From: Simon Davis
Sent: 21 August 2018 14:17
To: Planning.Responses
Subject: FW: Land to the rear of 41-47 Pevensey Road BR/229/17

Further Drainage Engineers response

From: Laura Gibbons
Sent: 21 August 2018 13:07
To: Simon Davis
Subject: RE: Land to the rear of 41-47 Pevensey Road BR/229/17

Typical ground floor/ wall detail

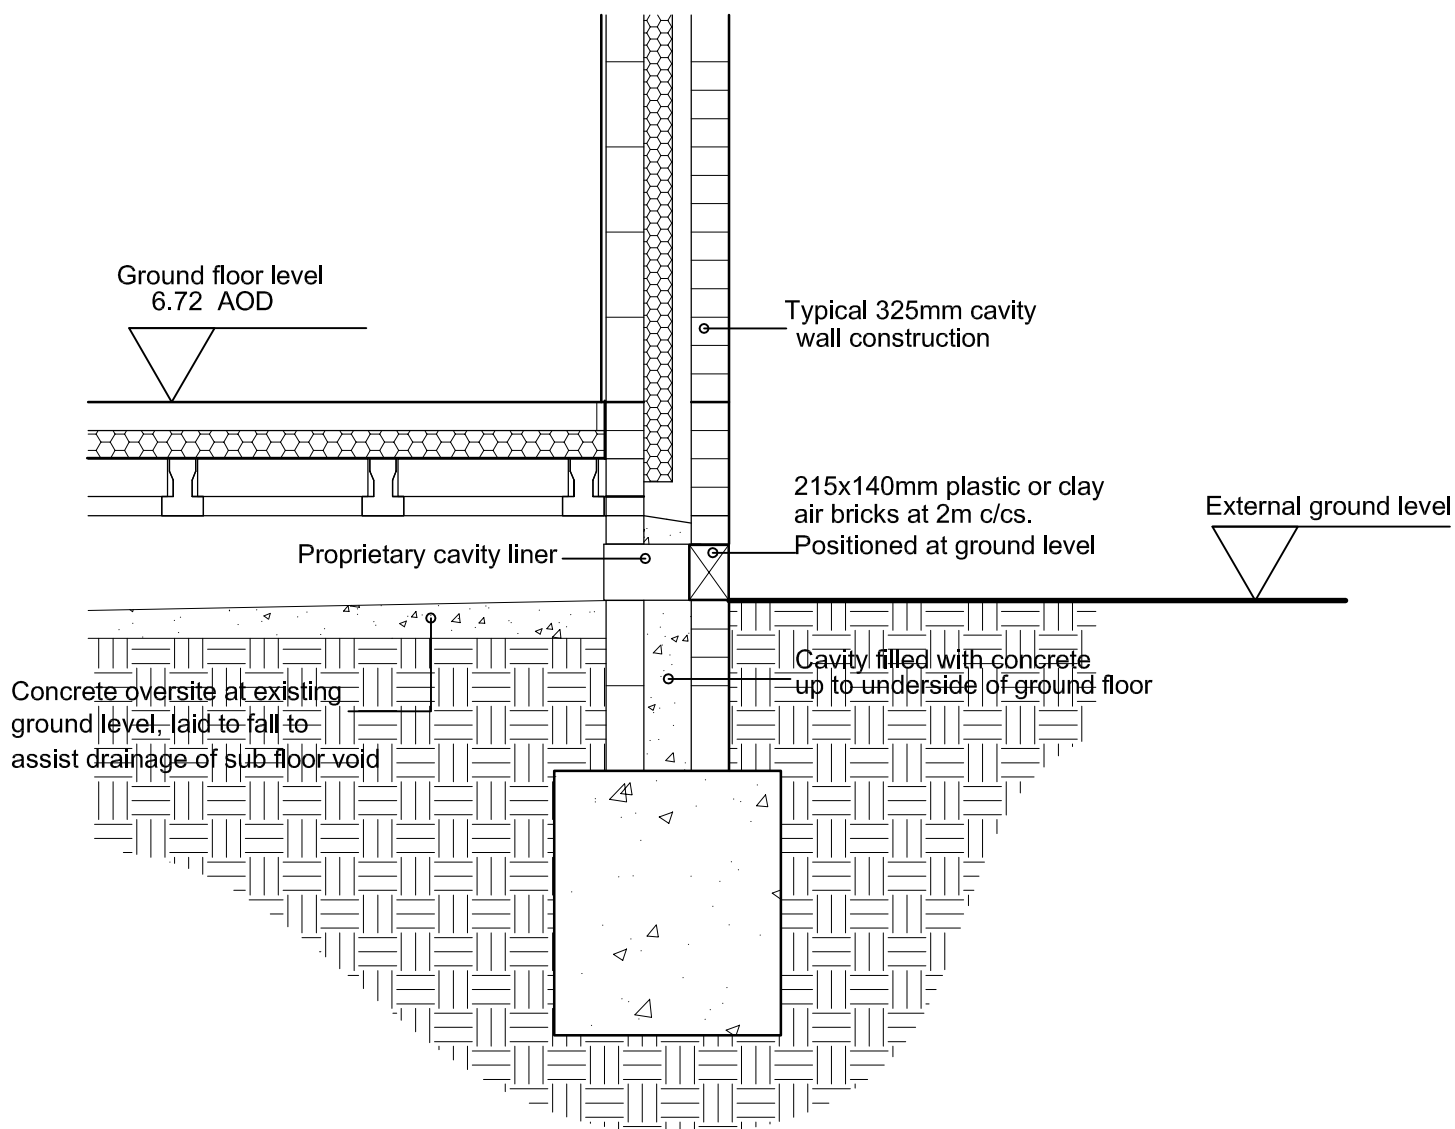
I am concerned regarding the proposals to actively look to flood the sub floor void of a building, I would strongly advise that the applicant discusses this with insurance bodies.

Normally if we know a building is at risk of flooding we do quite the opposite, to ensure that the minimum impact is going to occur to the property, i.e. flood resilience measures to ensure flood depths of 0.6m don't get into the building. It seems like a clutching at straws attempt to permit development in a flood risk area and minimise the requirements for mitigation.

I would also be concerned about the air bricks blocking up and not allowing the water in, so the building footprint/ volume causing flood water to be displaced to a greater extent than that allowed for. I'd also need to see calculations to see that ingress velocities through the bricks would be sufficient.

Debris is prevalent in flood waters, flood waters could also be contaminated with sewerage. If the below proposals to provide excess air bricks were to be carried out, how would the sub floor volume be cleared out after a flood event?

that normally the sub floor void would be vented via 215x65 air bricks at approximately 3m c/cs. 215x140 air bricks at 2m c/cs are proposed in this case. Larger openings could also be provided on each elevation to provide access for inspection. A typical wall detail is attached.
